Subject: RE: Planning Consultation on: P/88/22/DOC

Application No: P/88/22/DOC

Site Address: Land North of Sefter Road & 80 Rose Green Road Pagham

North of Sefter Road, Pagham – P/88/22/DOC Comments Tracker			Initial Issue Date: 12-10-2022 Issue Date: - Revision 1.0		
	ADC Drainage Comments 11-10-22	Applicants Response	ADC Drainage Comments 18-11-22		
	Initial/Planning:

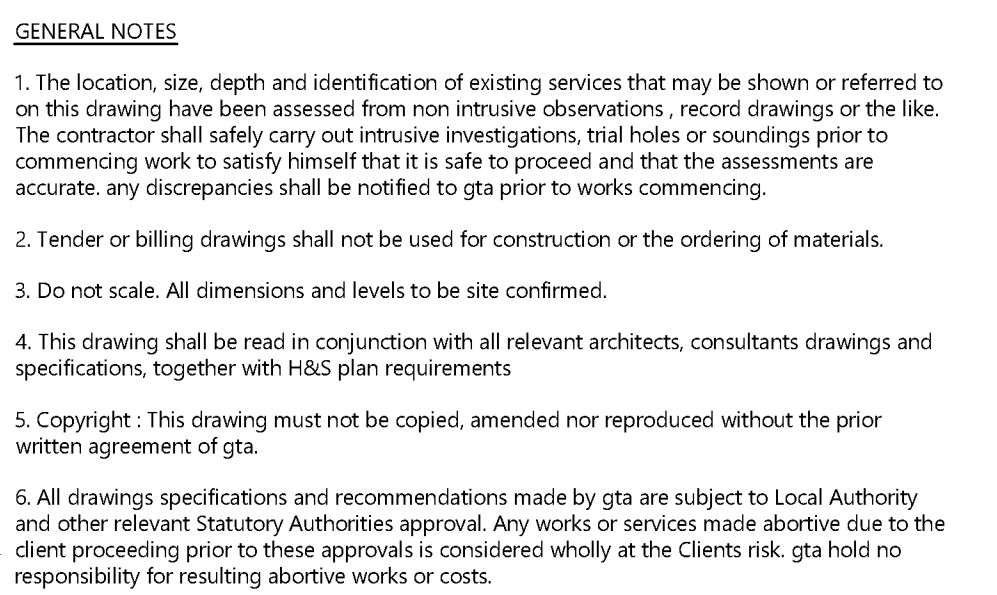
57.	Drawings 1601/P9 & 1602/P9 shows the anti-tank culvert running underneath new S38 road. If the existing culverts are damaged or unsuitable for additional vehicle loading these may need to be replaced and/or protected.

Drawing Number	Rev.
10768/1810	P8

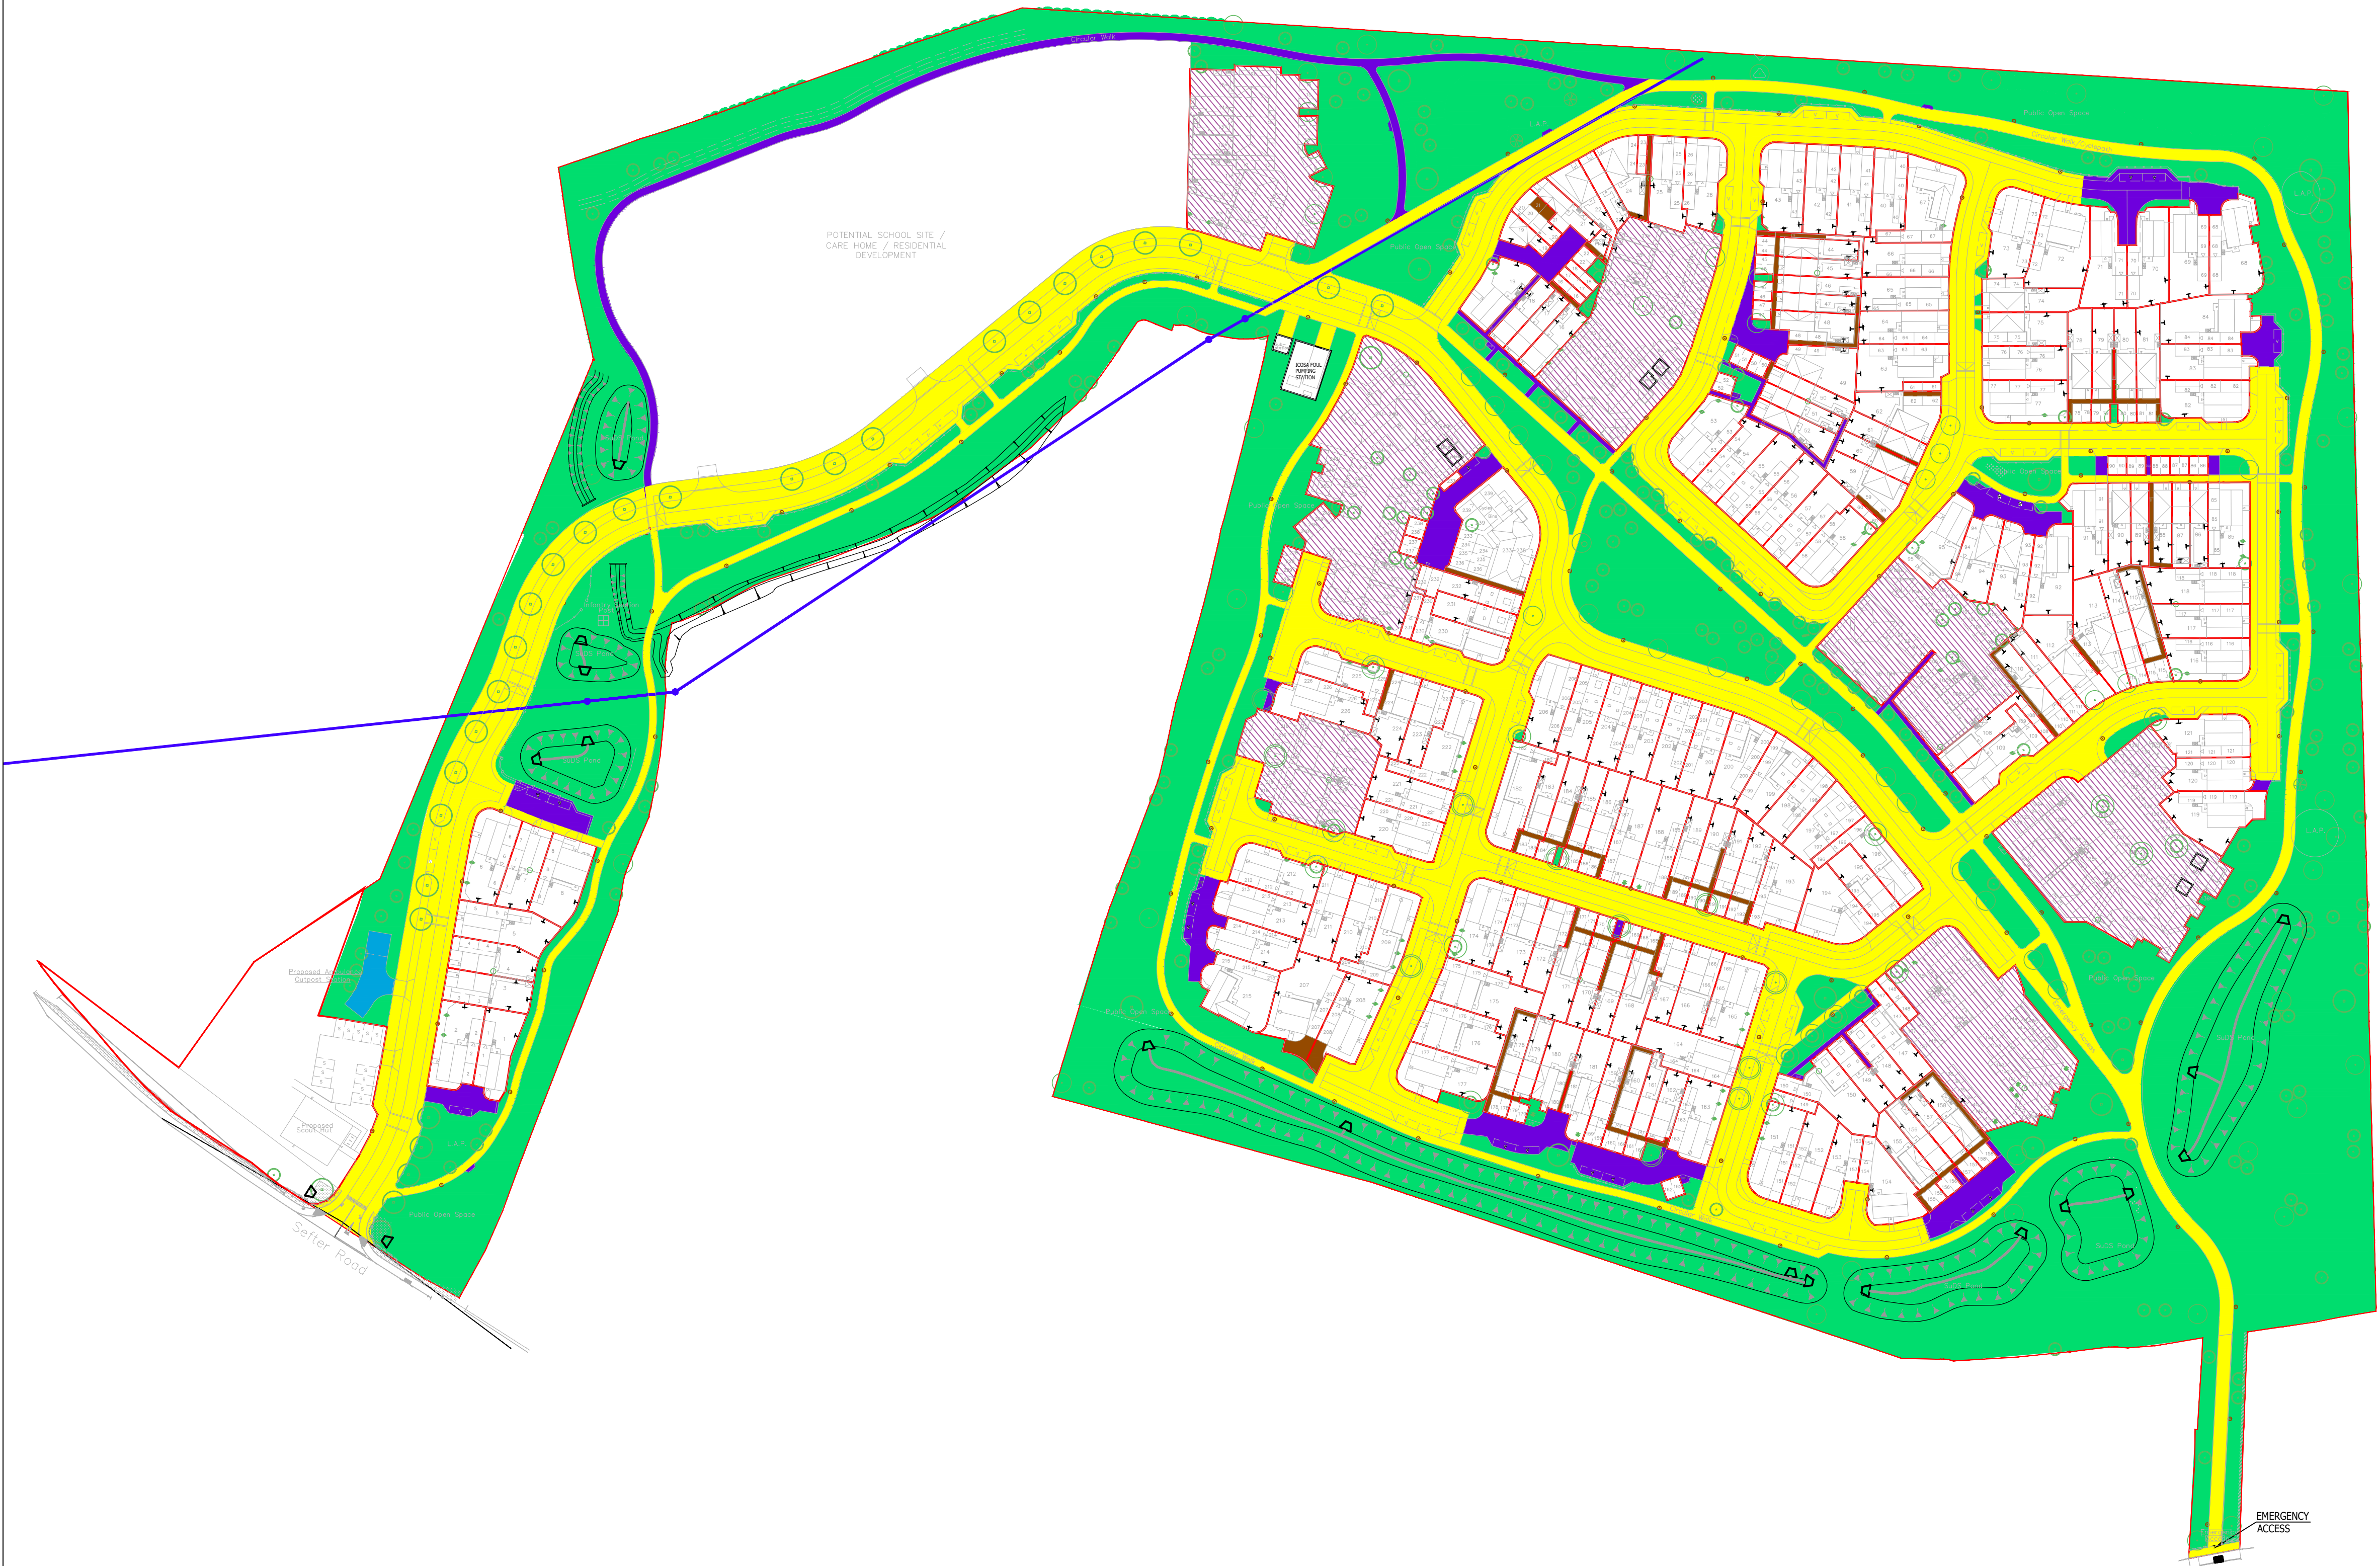
39.	Please advise if ICOSA are adopting the SW basins and if these comply with their design criteria/policy, in addition to DCG.	Icosa Water will not adopt attenuation ponds	Noted, with reference to conveyance drawing 1810 these area re to be 'privately managed land'. Please provide details of the management company arrangement in due course.
